From: Anita Gardner <Anita.Gardner@arun.gov.uk>
Sent: 18 December 2020 08:23
To: Planning.Responses <Planning.Responses@arun.gov.uk>
Subject: FW: Rustington Golf Centre Application number A/131/20/PL

Following our discussions, I can advise that the Council will not ask the applicant to discharge condition 3 because the matters required by the condition were shown and approved in the original permission. This e-mail correspondence will be uploaded against the application accordingly.

Dwg No.
20-20099-AP09

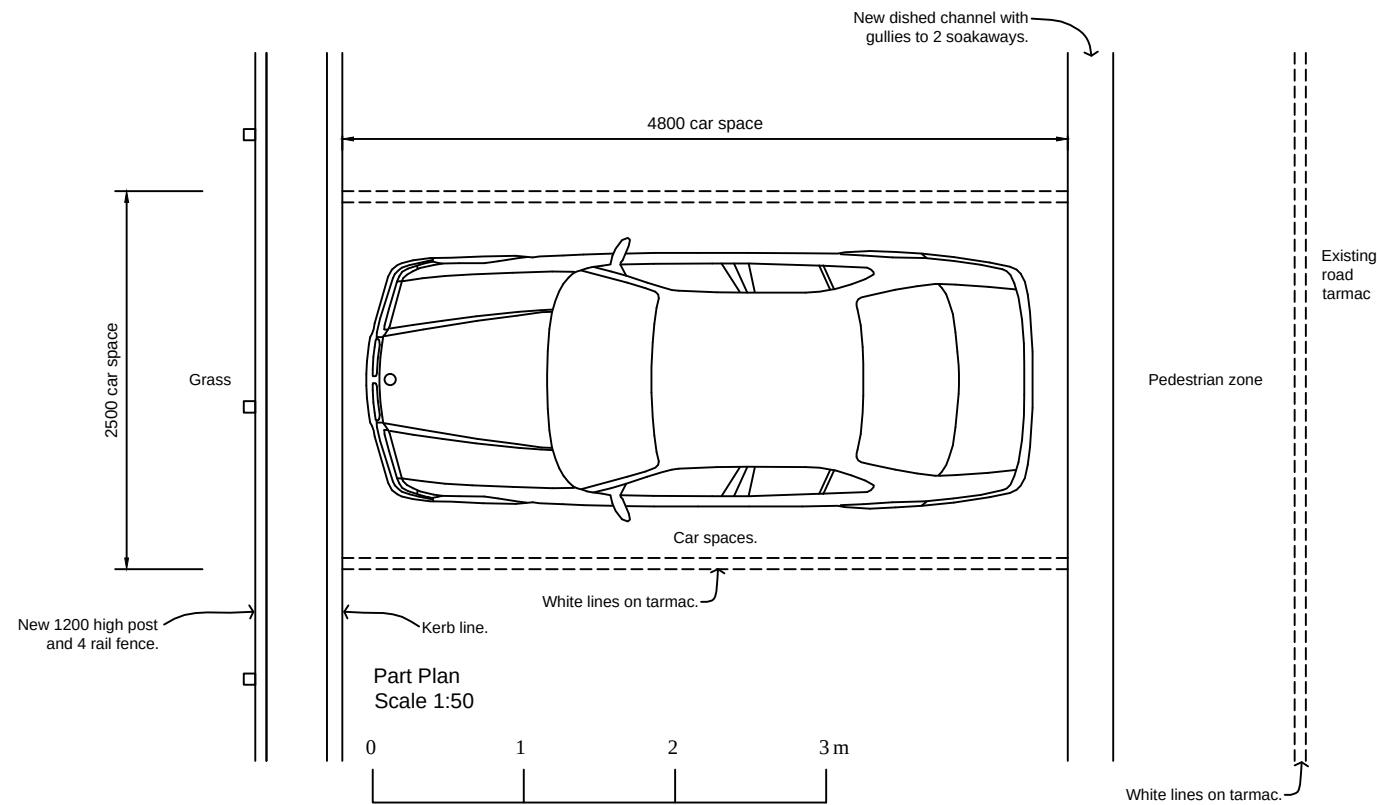
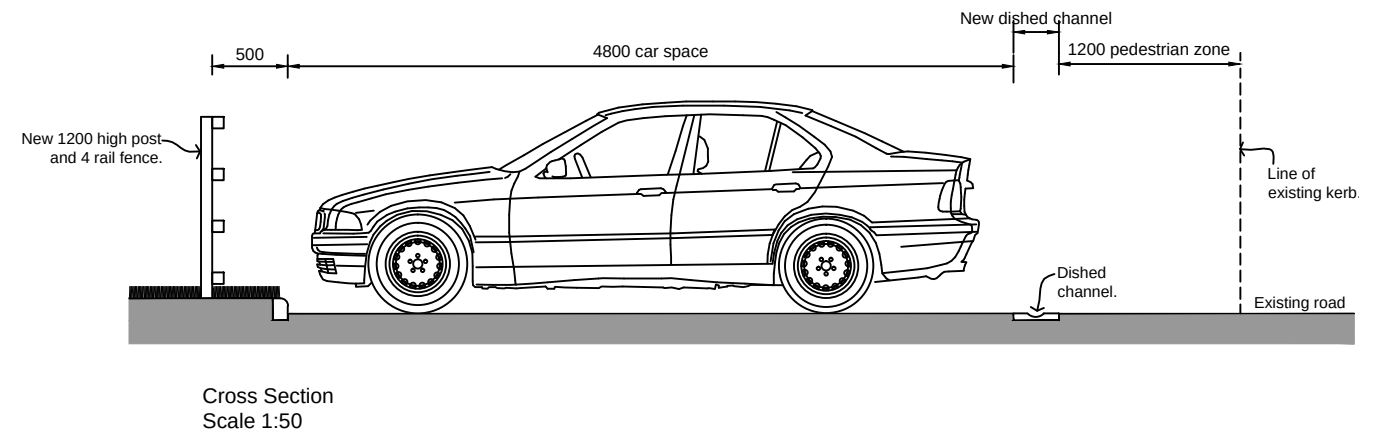
Thanks Anita.
I am a bit confused. Approved drawing AP09 shows car spaces dimensioned at 2.5m x 4.8m.
Is this not sufficient?
Regards
Brian

Brian,
I have had a response from County Highways they would like to see the parking dimensioned in any submitted details to discharge the condition. Provided they are constructed in accordance with County Standards of 2.4 by 4.8 metres they are likely to be acceptable.
Regards
Anita Gardner

Could you just explain what is required to meet Condition No 3 regarding car spaces.
The application drawings indicate the number, size and location of spaces and surface materials and description of kerbing etc.

If they exceed the width requirement that should be acceptable. I would suggest that you submit a DOC with the plan originally submitted and I will consult County and check that they are happy with the details.
